Item No.	Report of the Head of Development Management and Building Control	
Address:	82-84 HIGH STREET RUISLIP	
Development:	Creation of 6no. self-contained flats with associated cycle and bin storage, following the change of use of first floor from office (Class E) to residential (Class C3), the erection of a two storey rear extension with balconies and terraces and alterations to rear building including an additional storey and terraces. Retention and reconfiguration of the Class E unit at ground floor level with alterations to fenestration.	
LBH Ref Nos:	78935/APP/2026/418

Accordingly, the application is recommended for refusal.

Figure 1: Existing & Proposed Front Elevations

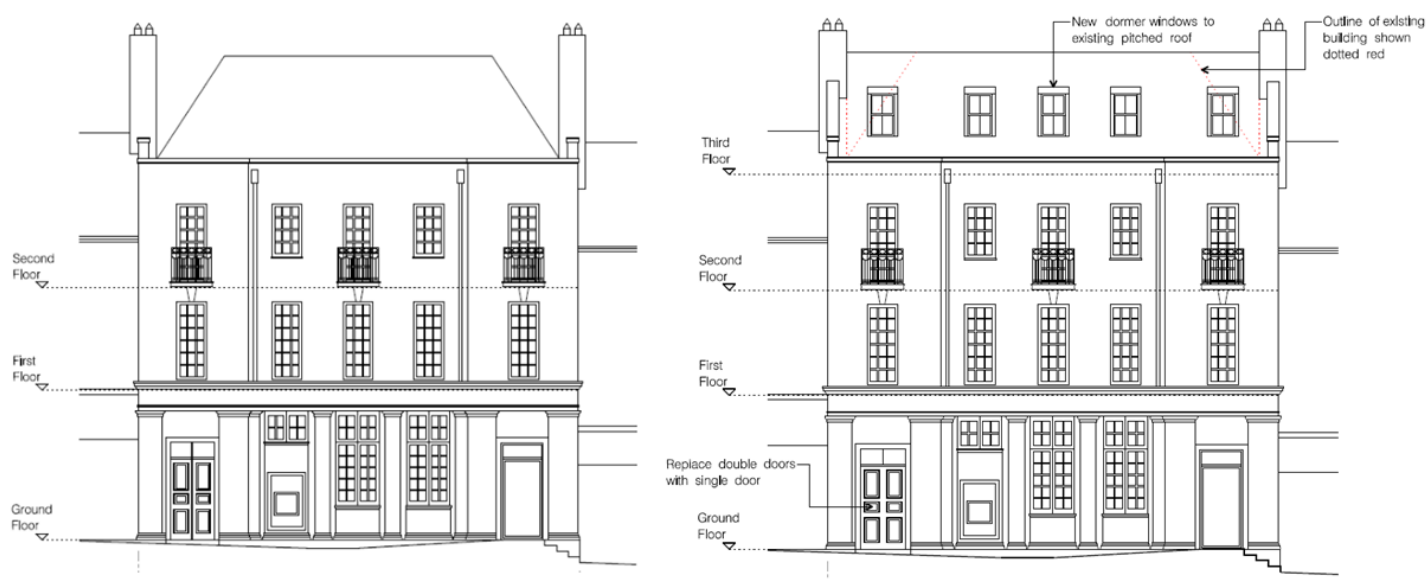
The proposal comprises a series of alterations to the locally listed building, including substantial changes to the roof form through infilling of the hipped roof between the existing chimney stacks, with tall blank party wall parapets, the introduction of five front dormers, and the addition of a rear roof extension with a mansard-like form incorporating a roof terrace and 1.8m high privacy screening. These works are combined with a two-storey rear extension and alterations to fenestration, including replacement of the front door. In addition, the scheme includes further development to the rear building, which is connected to the host building via a ground floor link, involving the addition of a further storey with a mansard roof and terrace.

Collectively, these works would materially alter the established form, proportions and composition of both the principal building and its rear element. The existing simple hipped roof of the locally listed building, which reads clearly in conjunction with the symmetrically positioned chimney stacks, would be significantly altered through infilling, dormers and additional bulk, resulting in a more complex and visually heavier roofscape. The rear roof extension, projecting across almost the full depth of the building and incorporating a terrace with 1.8m high screening, would give the appearance of an additional storey and would visually compete with and obscure the original roof form.

As a result, the proposal would disrupt the established proportions of the building, diminish the visual prominence of the chimney stacks, and erode the architectural integrity of the asset. Given the building's prominent corner location, these changes would be clearly perceptible in public views and would significantly diminish its contribution to the wider townscape and the character and appearance of the Conservation Area.

Figure 2: Existing & Proposed Rear (west) Elevation

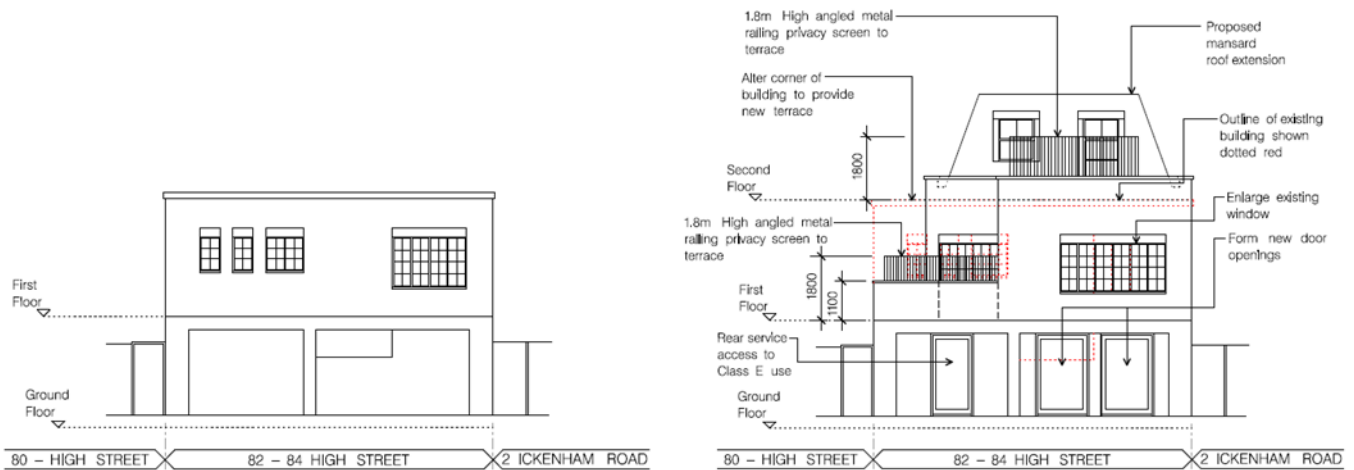
The significant upward extension to the rear building, increases its height by approximately 3 metres to facilitate an additional storey in the form of a duplex unit. Whilst the existing approval includes alterations to the rear element, including a infill extension and terrace, the current proposal represents a clear intensification, introducing a mansard-style roof with a substantial flat roof element and terraces at both levels. The upper terrace would require 1.8m high privacy screening, which would appear as a visually bulky addition and further increase the perceived massing of the structure.

The rear building is currently read as a clearly subordinate and ancillary element to the principal locally listed building. However, the proposed increase in height and bulk would materially alter this relationship, resulting in a form of development that competes with, rather than defers to, the host building. The cumulative impact of the additional storey, crown roof form, terraces and privacy screening would result in a visually dominant, overbearing and overdeveloped form of development.

When viewed from the rear, including from the adjacent public car park and alleyway, the extension would appear as a substantial and intrusive addition, obscuring views of the locally listed building

and diminishing the legibility of its original form. In these views, the development would read as an excessive and dominant addition that disrupts the established hierarchy of the site. As such, the proposal would fail to remain subservient to the locally listed building and would result in further harm to the significance of the non-designated heritage asset and the character and appearance of the Conservation Area.
